Essex County Council's response to the Secretary of State second consultation dated 20 November 2023

Thank you for consulting Essex County Council (the Council) and requesting for our comments on item 10 and 12 of the second consultation letter in connection with National Highways' application for development consent for the proposed A12 Chelmsford to A120 Widening Scheme.

Drawing title
**TRAFFIC REGULATION MEASURES
SPEED LIMITS
SHEET 14 OF 21**

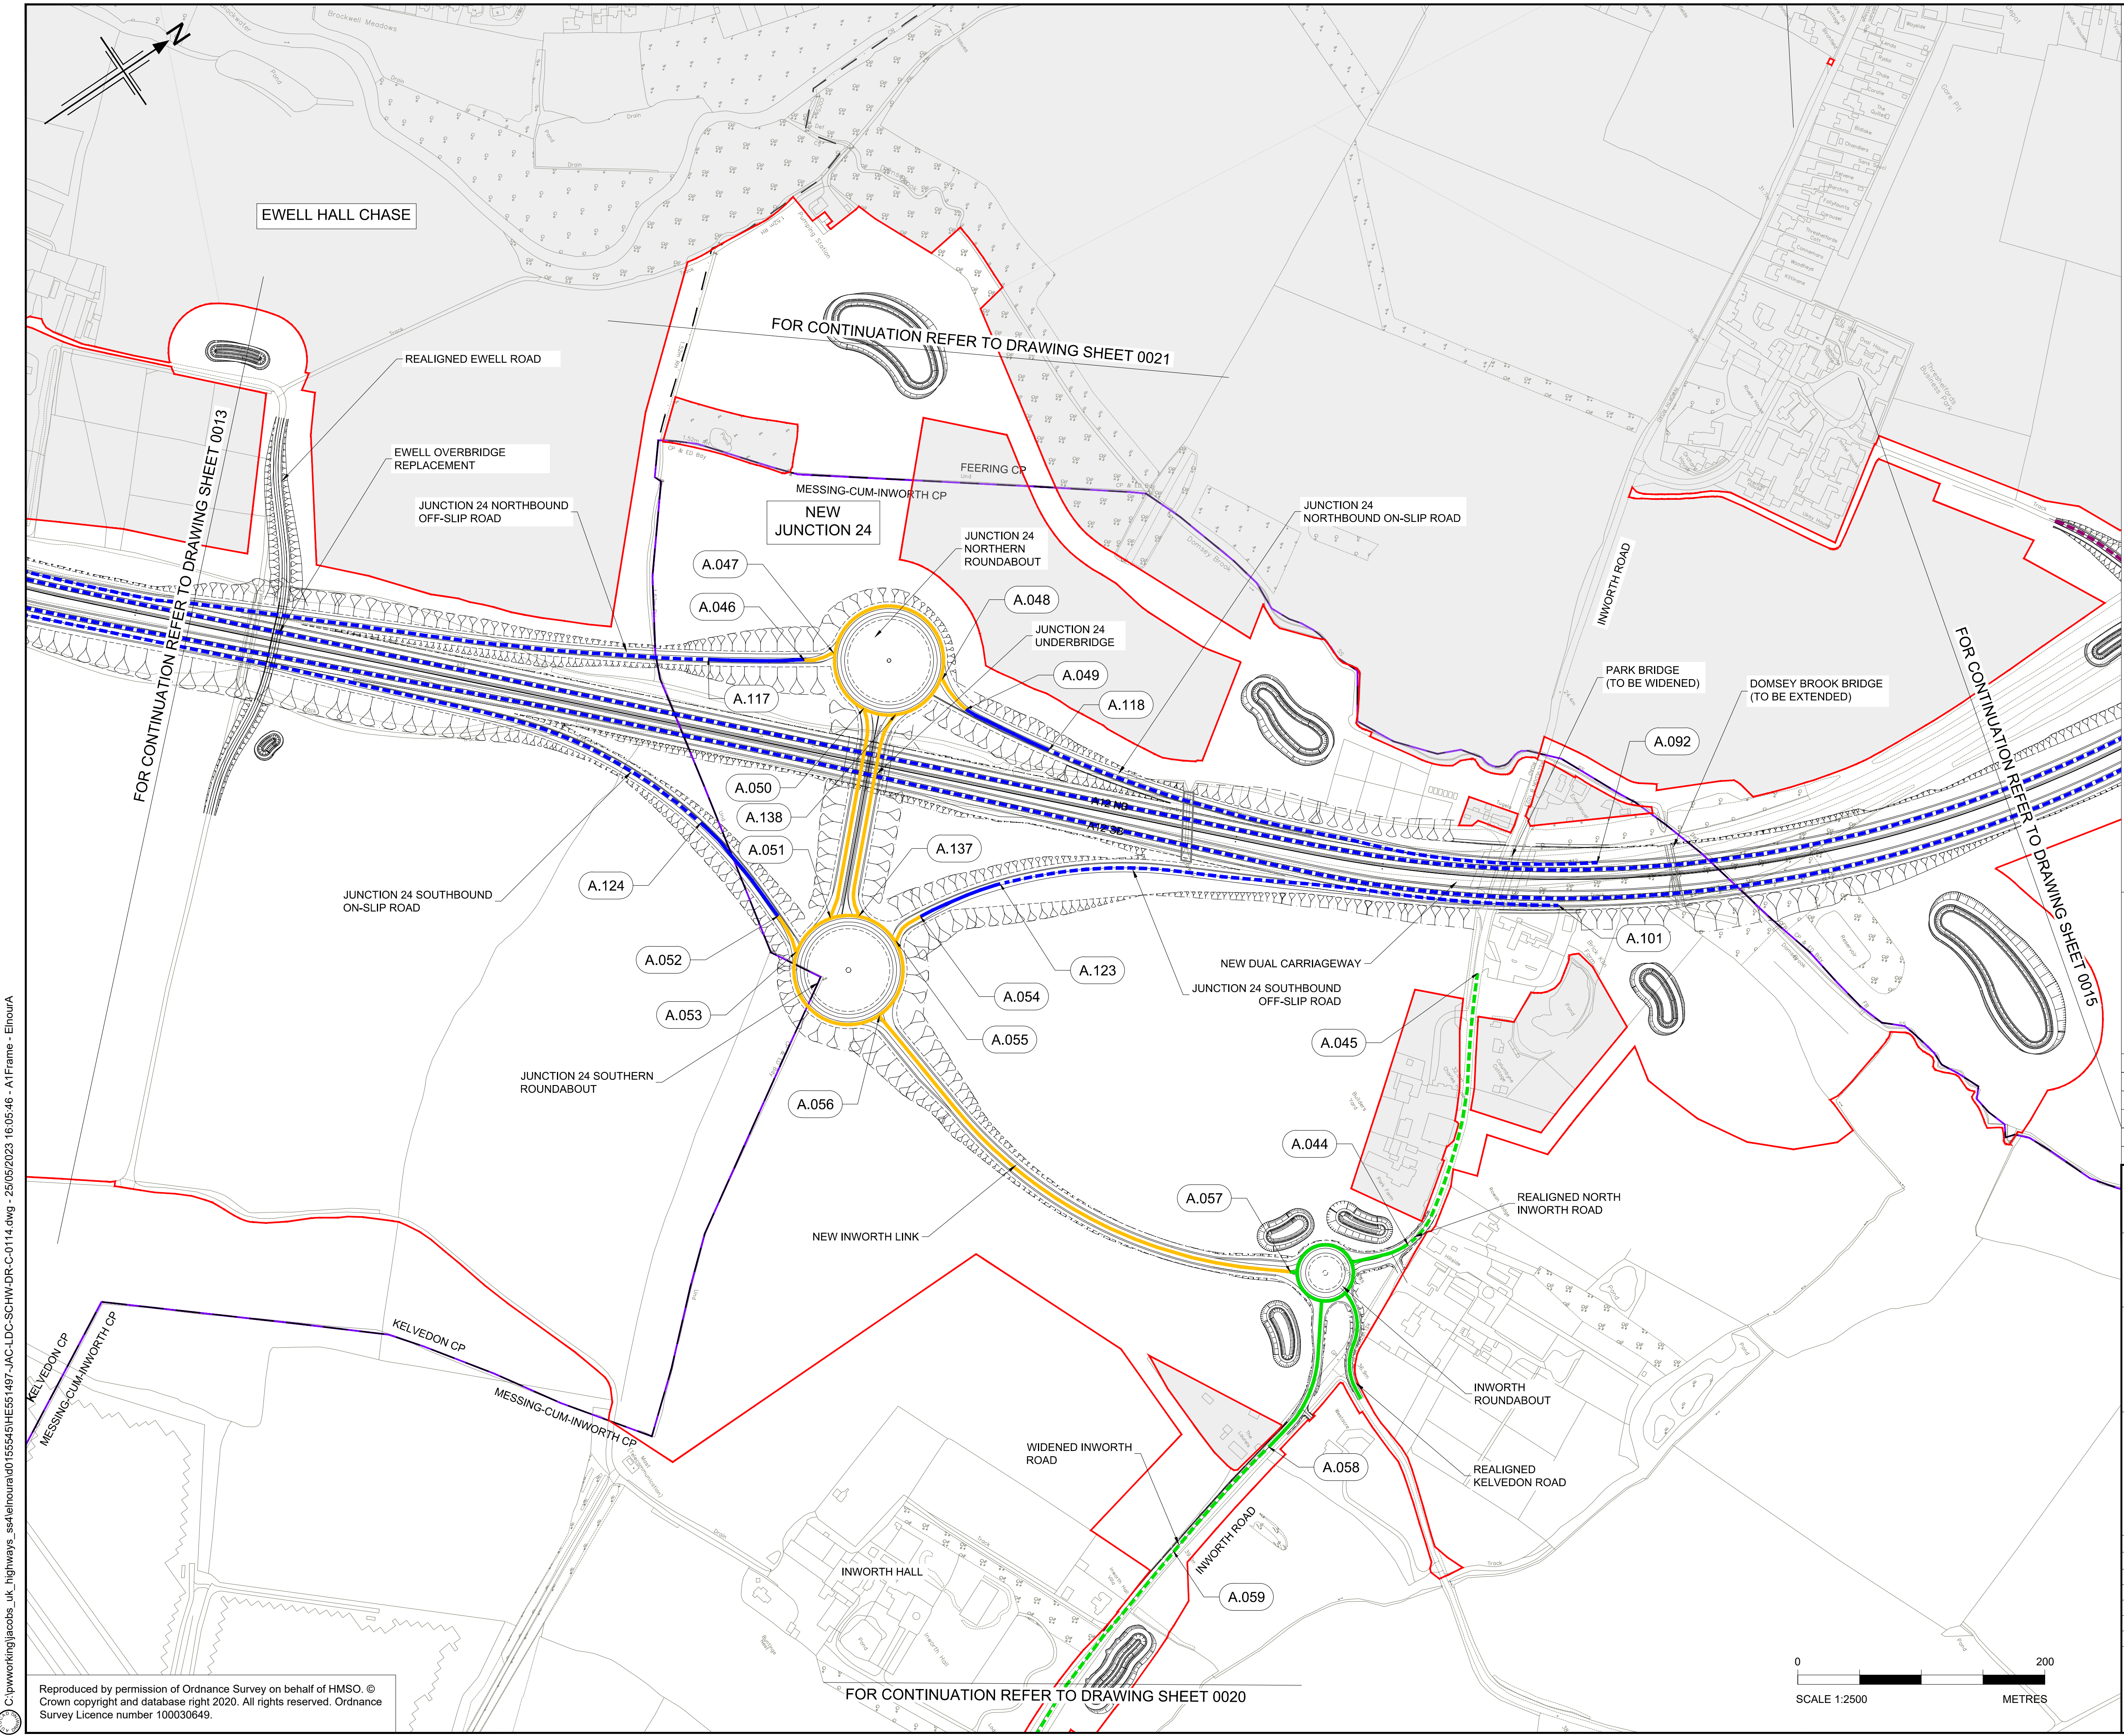
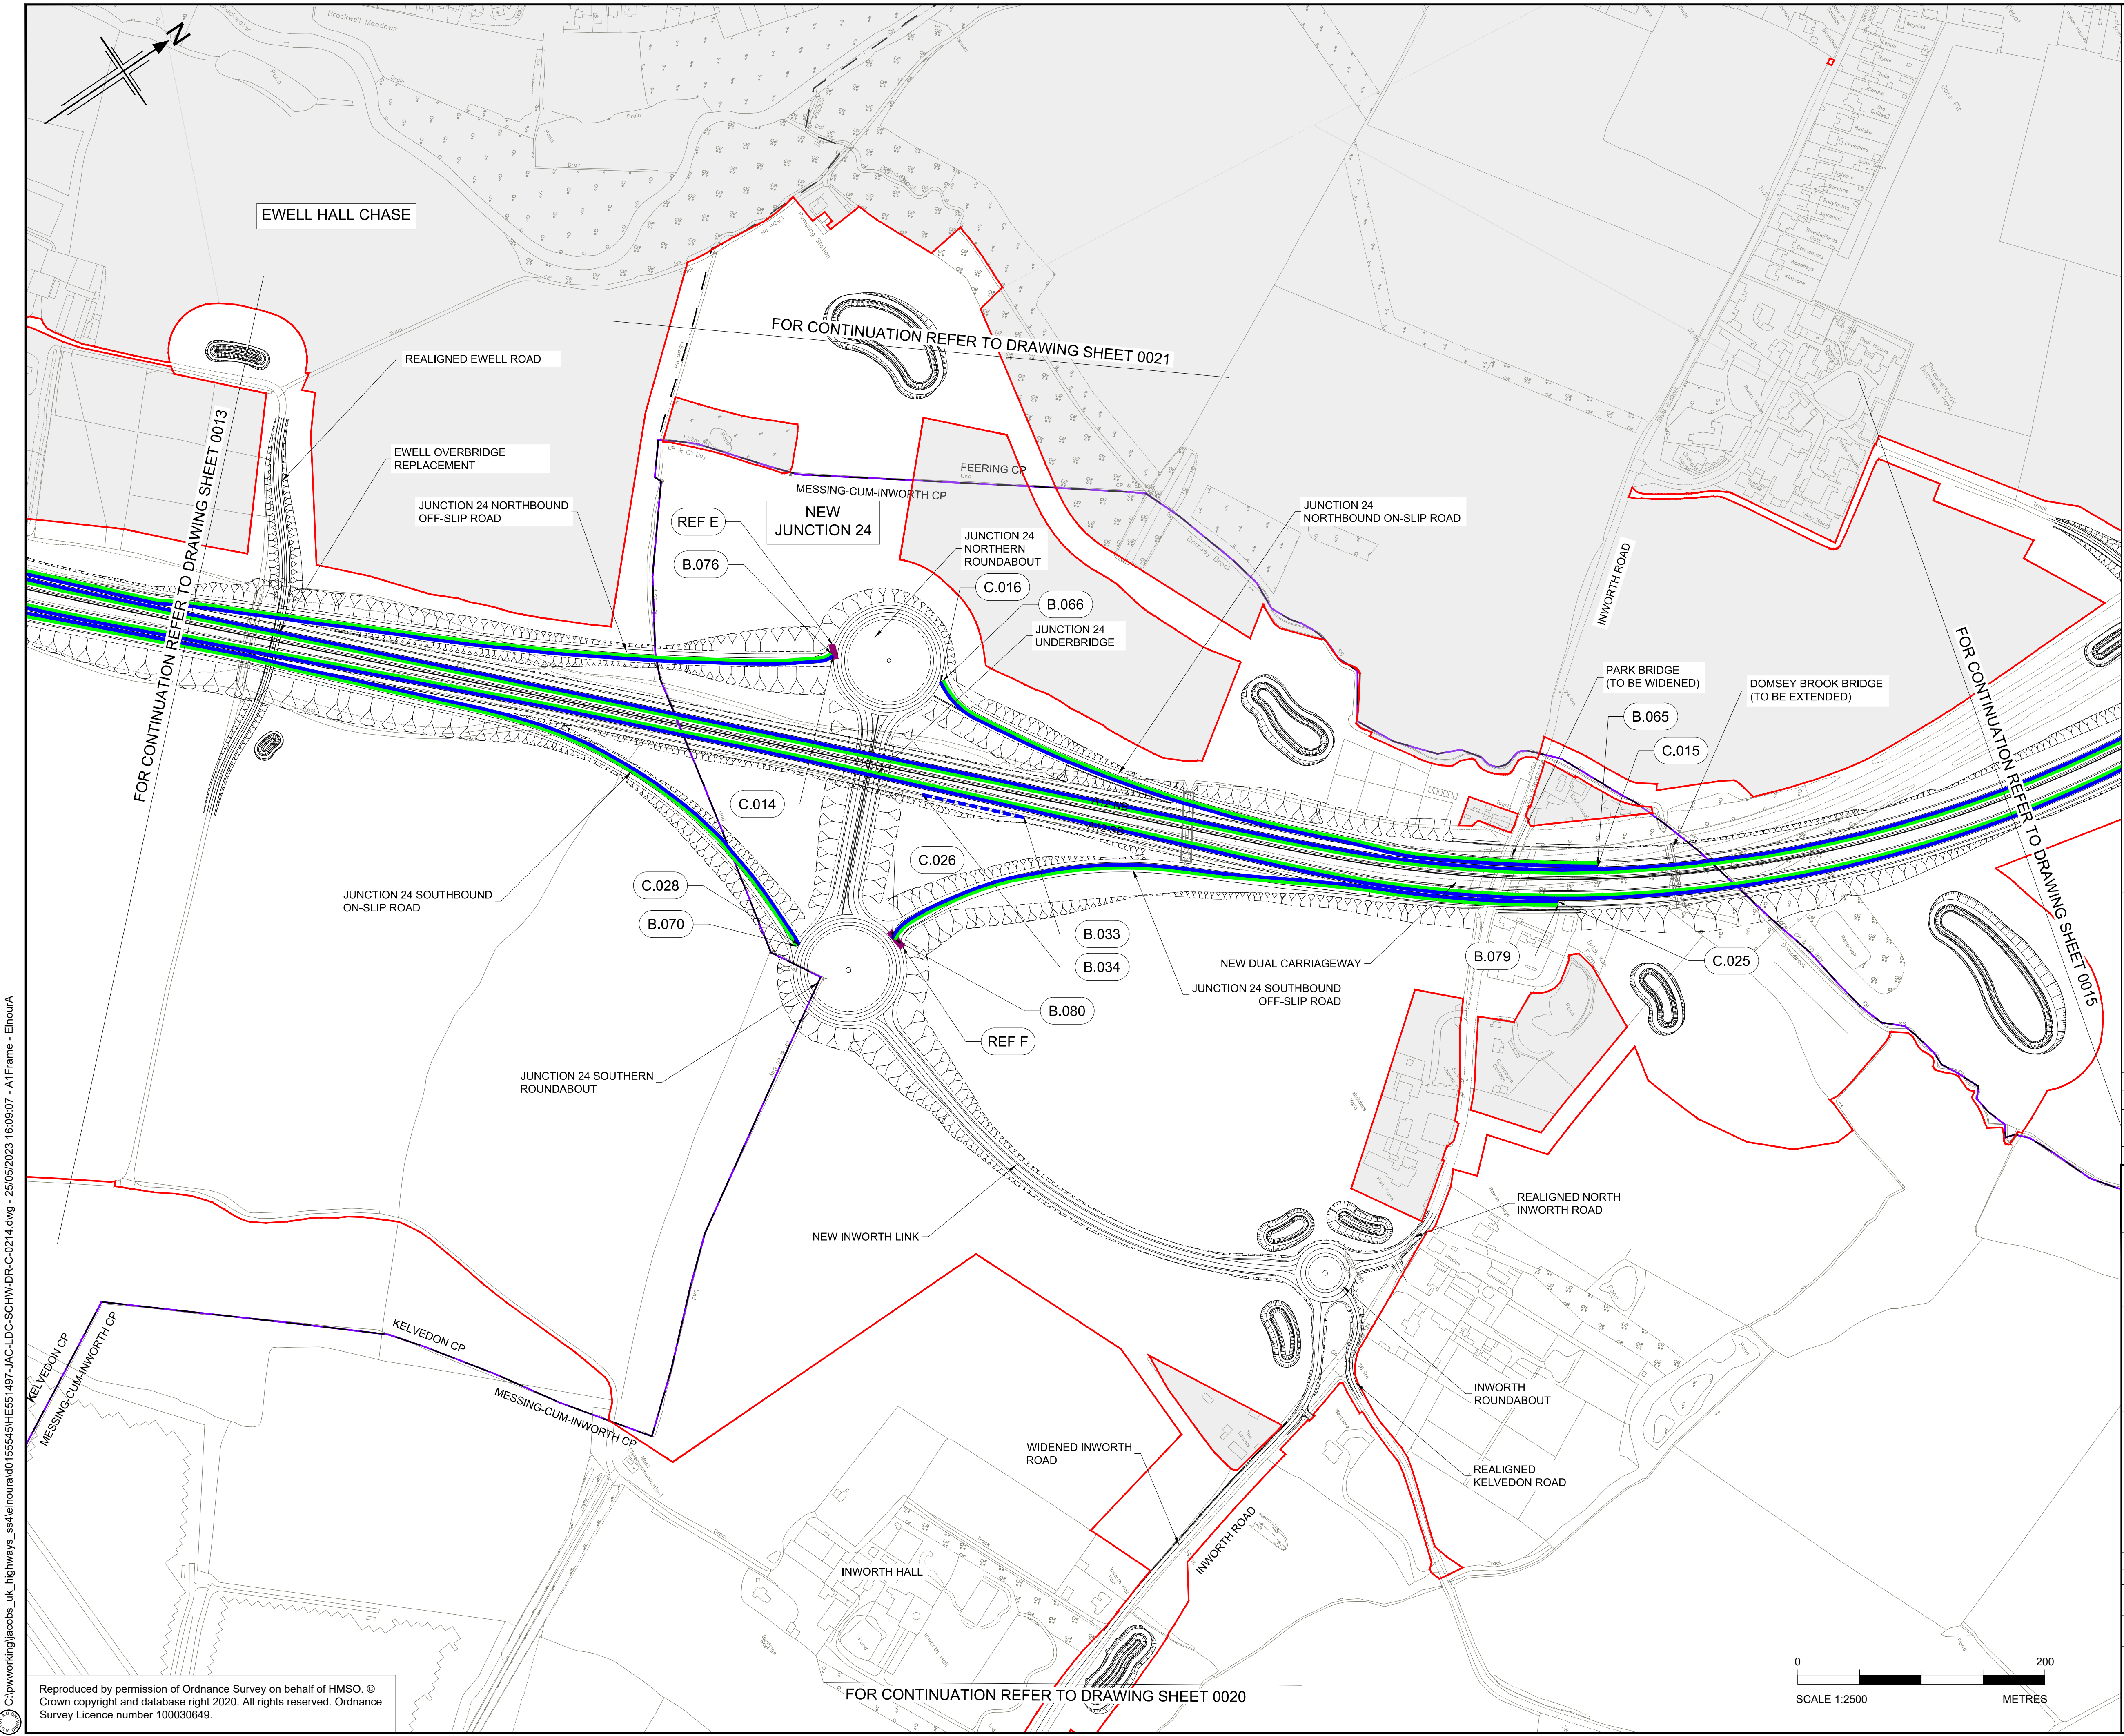
Messing- cum- Inworth CP	A12 Junction 24 underbridge (southeastbound side), from point A.137, 6 metres north west of the centre point of the junction 24 southern roundabout to point A.138, 6 metres south east of the centre point of the junction 24 northern roundabout, a distance of 165 metres.	Removal of restricted road status	This road forms part of the SRN maintainable by the Applicant and is the responsibility of the Applicant to specify an appropriate speed limit
Copford CP	New Wishingwell Bridge Road (both sides) from point A.079, 16 metres south of the centre point of the Wishingwell Farm roundabout to point A.080, 83 metres south of the same point, a distance of 67 metres.	Removal of restricted road status	NSL

- c. Inworth Road Roundabout – The Council’s response to REP3-012 is documented in REP4-075 Page 22, where we outlined our case why the adoption of local road standards isn’t appropriate. As a result, we maintain the view that additional measures proposed in the Council’s Inworth, Messing & Tiptree Mitigation Options Technical Note [REP3-033] is required to mitigate the impact of the traffic flow changes in the vicinity of Messing, Inworth and Tiptree.
